**ENTECH**  
ENGINEERING, INC.

Re: Response to PCD Engineering Review  
Soil, Geology, & Geology Hazard Study  
Sterling Ranch East – Preliminary Plan No. 1  
Parcel Nos. 17, 18, 22, 23, 24, 26, 37, & 38  
El Paso County, Colorado  
Entech Job No. 220571

## **PCD ENGINEERING DIVISION REVIEW COMMENTS AND ENTECH ENGINEERING, INC. RESPONSES**

STERLING RANCH EAST PRELIMINARY
PLAN NO. 1
PRELIMINARY GRADING & UTILITY PLAN

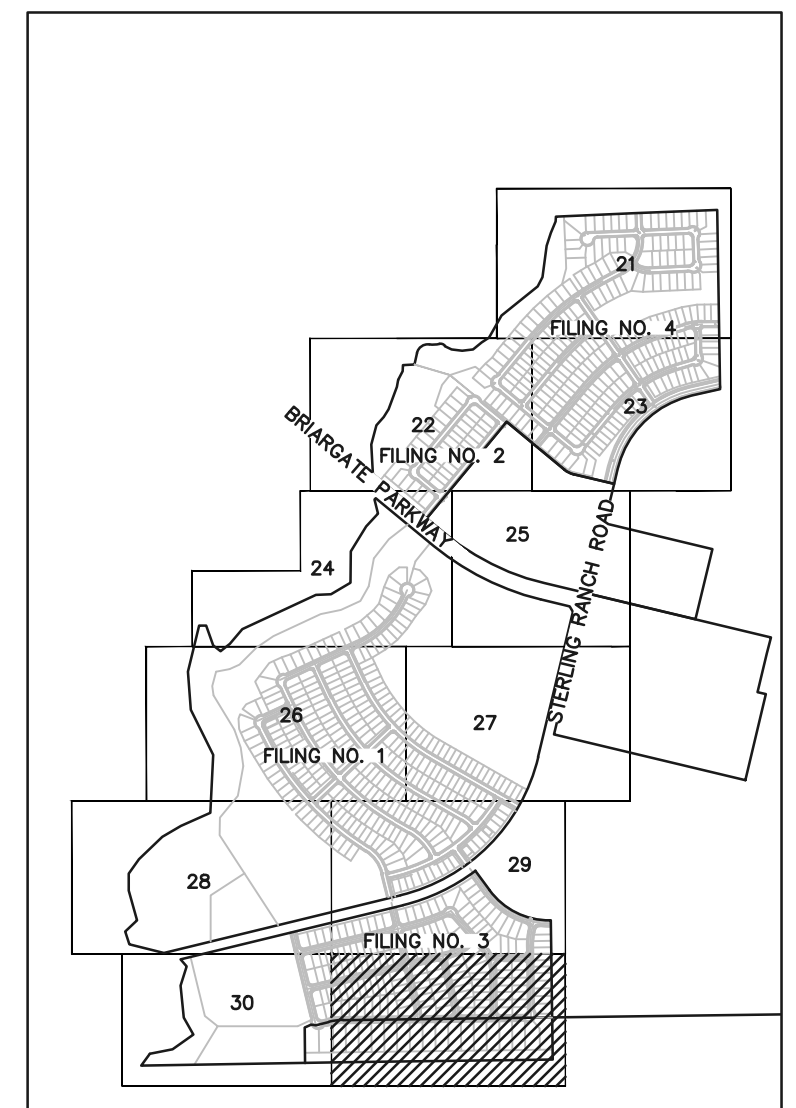
**PCD Engineering Comment:** “Specify what the monitoring program will be during and after the additional site investigation mentioned in the response to CGS comments and after site grading.”

be conducted as development plans are being prepared, and following completion of site grading. Basement feasibility should be evaluated on a block by block basis pending the results of additional site investigation and approved grading plans. Currently cuts of up to 7 feet are proposed in the general area of Test Boring No. 1A.
